**KIRKLEES METROPOLITAN COUNCIL
INVESTMENT & REGENERATION SERVICE**

Reference No:	2025/62/91858/E
Site Address:	23, Garfitt Hill, Gomersal, Cleckheaton, BD19 4QR
Description:	Removal of existing outbuilding and erection of replacement detached garage and outbuilding
Recommending Officer:	Elenya Jackson

DECISION - REFUSED

Officer Report

Drawing Title
PROPOSED

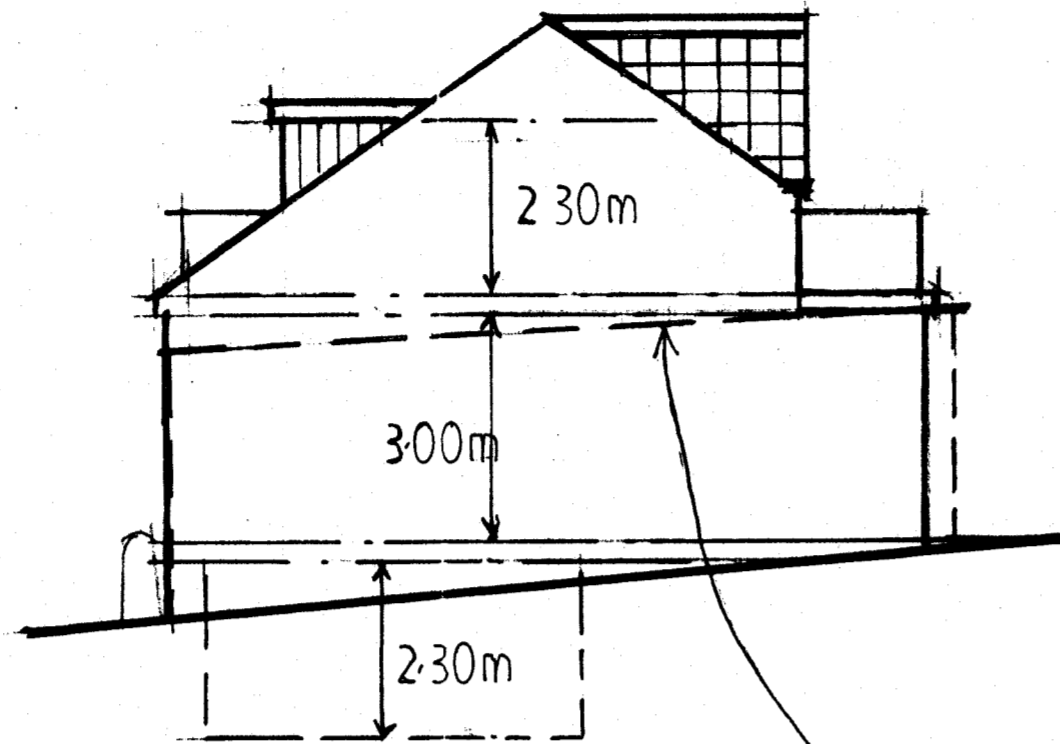
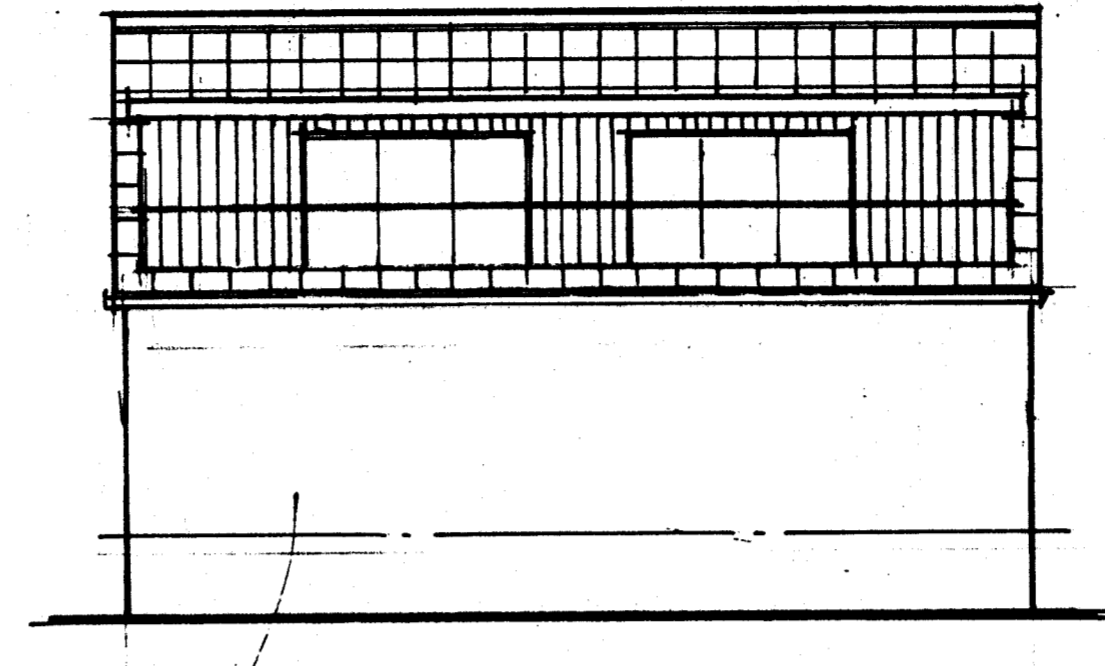
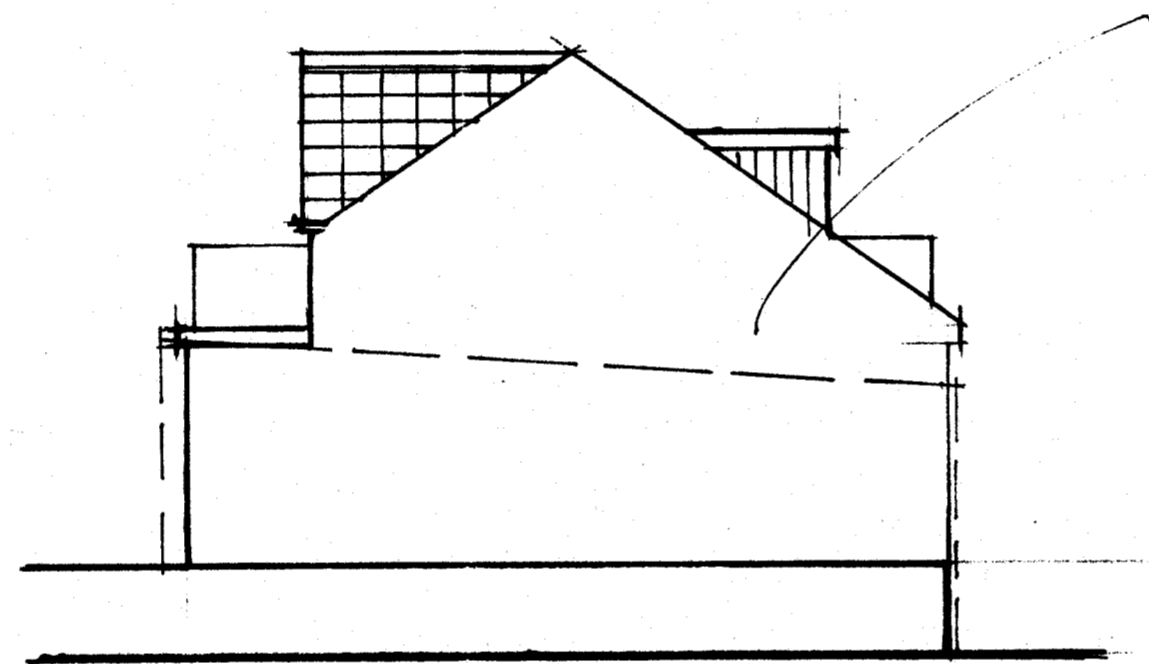
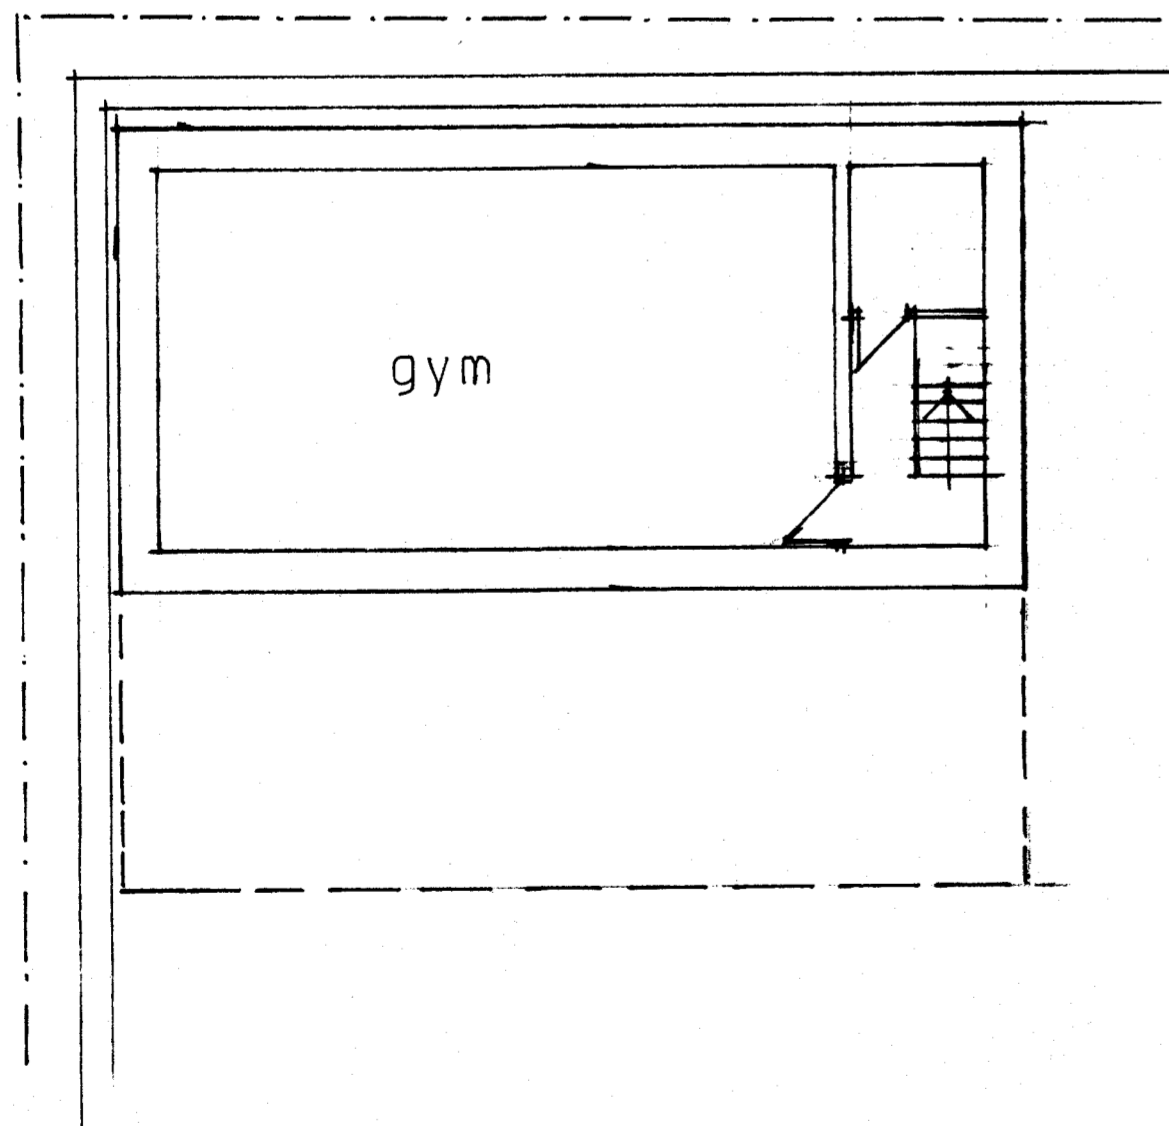
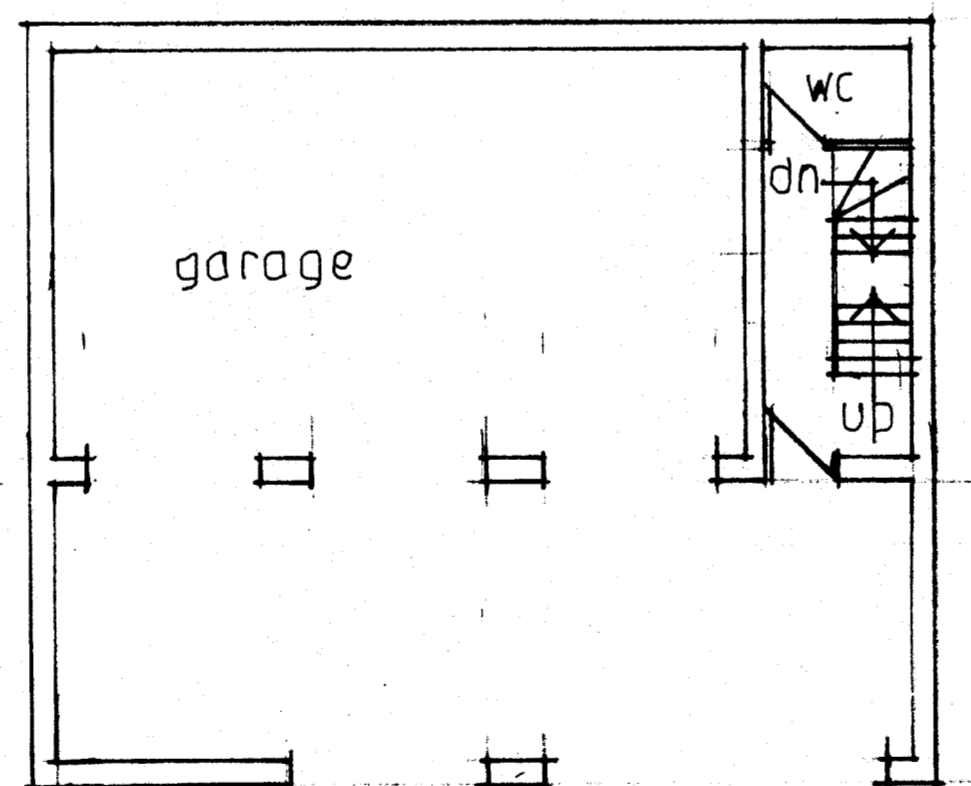
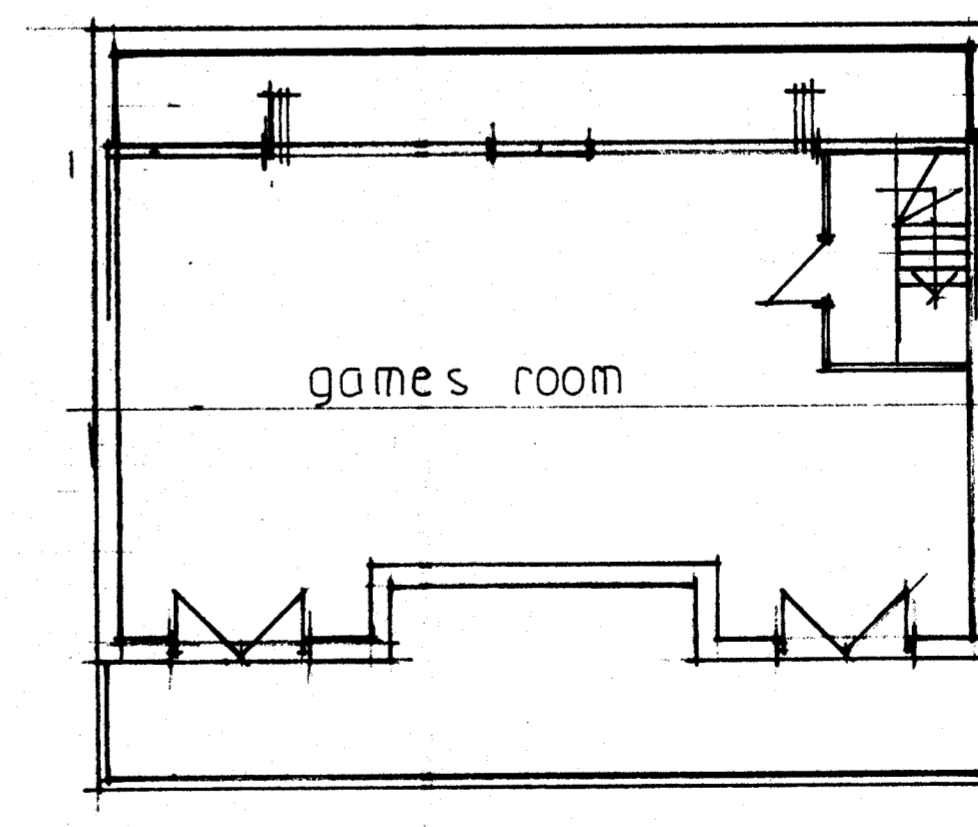
The proposed structure would be split over three levels with a maximum height of 6.8m above the current site level, a width of 12.6m and a depth of 10m.

The proposal would feature dormers on its front and rear elevation with corresponding balconies.

- **Existing building footprint:** approximately 131m²
- **Proposed footprint:** 121m² (ground floor), 73m² (lower ground), and 83m² (first floor due to inclusion of balcony)
- **Existing building volume:** approx. 405m³
- **Proposed building volume:** approx. 766.2m³ – an increase of 89%
- **Proposed maximum height increase:** approx. 4.1m taller than existing

When viewed in the context of the host building on site(no.23) the proposal would appear as a substantial development in the plot which would constitute a disproportionate addition over and above the size of the original dwelling and would not appear subservient to it (No. 23 Garfitt Lane), contrary to paragraph 154(c). The scale and mass increase would compete with the host dominating the space resulting in harm to the openness and character of the green belt.

The proposal would have an increase in height compared to the existing structure on site and overall scale which would increase the prominence of a structure from the public realm and wider vantage area. In addition, the development would have a substantial increase in volume of 89% compared

to the structure which would be removed to accommodate the development. It is considered by officers that, as a replacement building, the proposal would be materially larger than the one it replaces, failing to meet the criteria of paragraph 154(d) and detracting from the character and appearance of the green belt.

The outbuilding is of a scale, footprint, and design, such that it would not appear as a subservient addition to the host property and would compete as a standalone building to the host. Furthermore, the proposal represents a significant volume increase of 766.2m³ above that of the original building on site (no.23), which undermines the principle of the original dwelling remaining the dominant element on site.

The increase in height, along with the introduction of prominent first-floor gable ends and balconies, creates an overt vertical emphasis that contrasts

sharply with the existing building. As a result, the extension appears visually incongruous in relation to the host property and the wider site context.

Overlooking: The proposal would feature a balcony on the front and rear of the proposal. It is considered that this could provide the opportunity for additional views towards the properties amenity space and a screen would be required on the north elevation to limit any concerns regarding overlooking. This could be conditioned.

1. The development proposed, by virtue of its scale and design, would not appear subservient to the original dwelling and would compete and detract from the character and appearance of that dwelling. To permit

1. The proposed outbuilding, due to its scale, siting and design, would result in disproportionate additions to the original dwelling and a detrimental reduction in the openness of the Green Belt and harm to visual amenity. The proposed development would therefore represent inappropriate development within the Green Belt and no very special circumstances have been submitted to clearly outweigh the harm caused by reason of inappropriateness or other harm. The proposal would therefore fail to accord with the requirements of Policies LP24 (a) and LP57(a) of the Kirklees Local Plan and the National Planning Policy Framework.

No amended plans requested as a substantial redesign is required.
